Reviewed for Code Compliance  
Inspections Division  
Approved with Conditions  
Date: 12/01/17

**Terry Lacy** <tlacy@omlandyoga.com>  
To: Permitting and Inspections <buildinginspections@portlandmaine.gov>

To complete your commercial tenant fit up application, please submit the following information and plans:

1.1

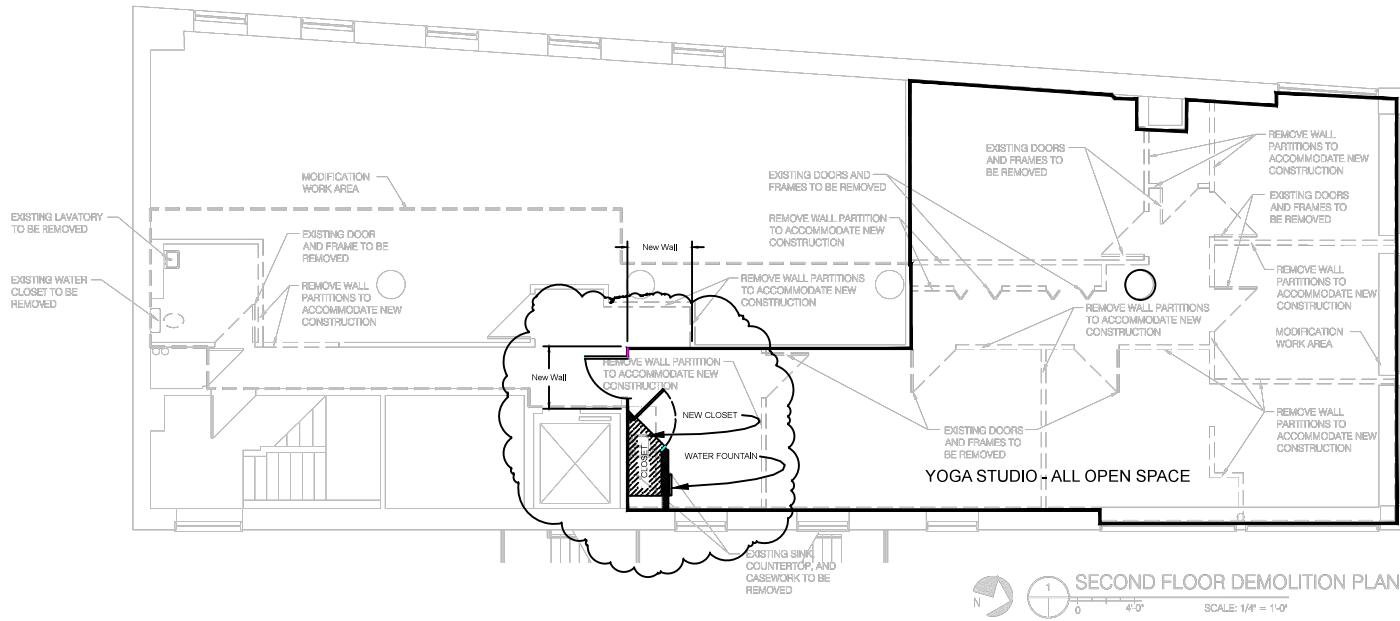
3. Your plan does not contain a lot of details. More details on attached drawing. Are the new walls you plan to install associated with the closet? They are not. Please send framing details for the closet/walls you plan to build. 2 x 4 stud construction, non bearing, partition walls, drywall sheath. Also provide information about the door(s) you plan to install - dimensions and product information. Two (2) doors, both 36" x 80", wood, single light, and are the same doors from the previous tenant, saved from demolition and relocated. Picture attached. How many doors are you adding - just the door on the closet? 2 doors: entrance door and closet door, identical. See attached plan with dimensions and notes.
